8th October 2018

Town & Country Planning Act 1990 (as amended)
Town & country Planning (Development Management Procedure) (England) Order 2015
Application for Planning Permission for Works or Extension to a Dwelling

Development Single storey front/side/rear extension
Location 29 Elm Grove Barnham

BLOCK PLAN AS EXISTING

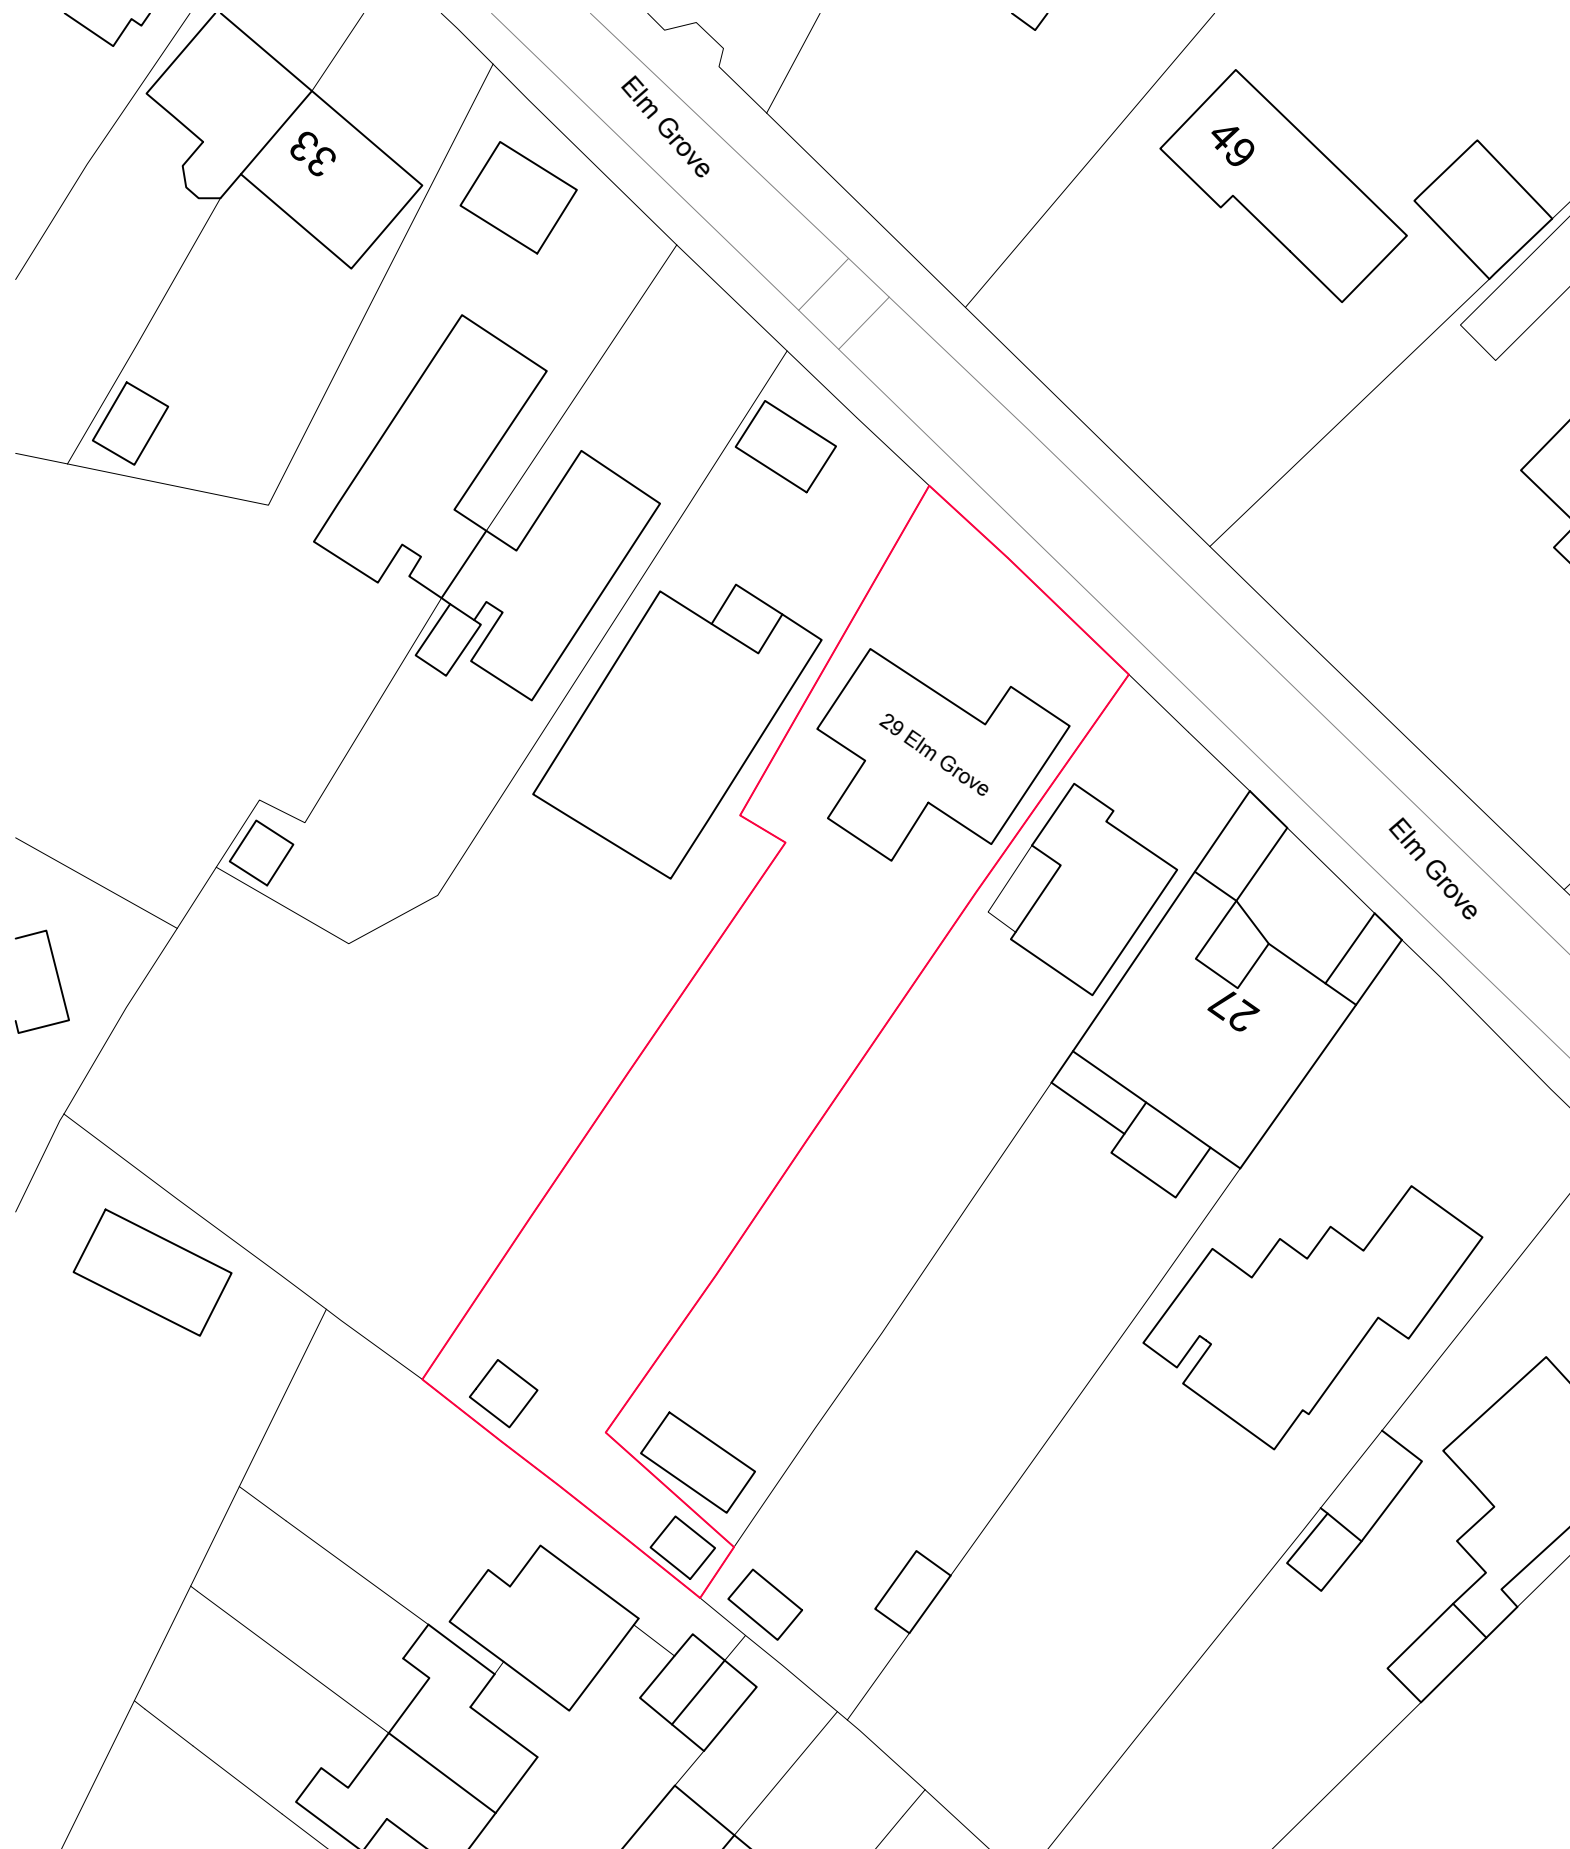
Block Plan

You are required to annotate all dimensions from the proposed extension to the boundary.
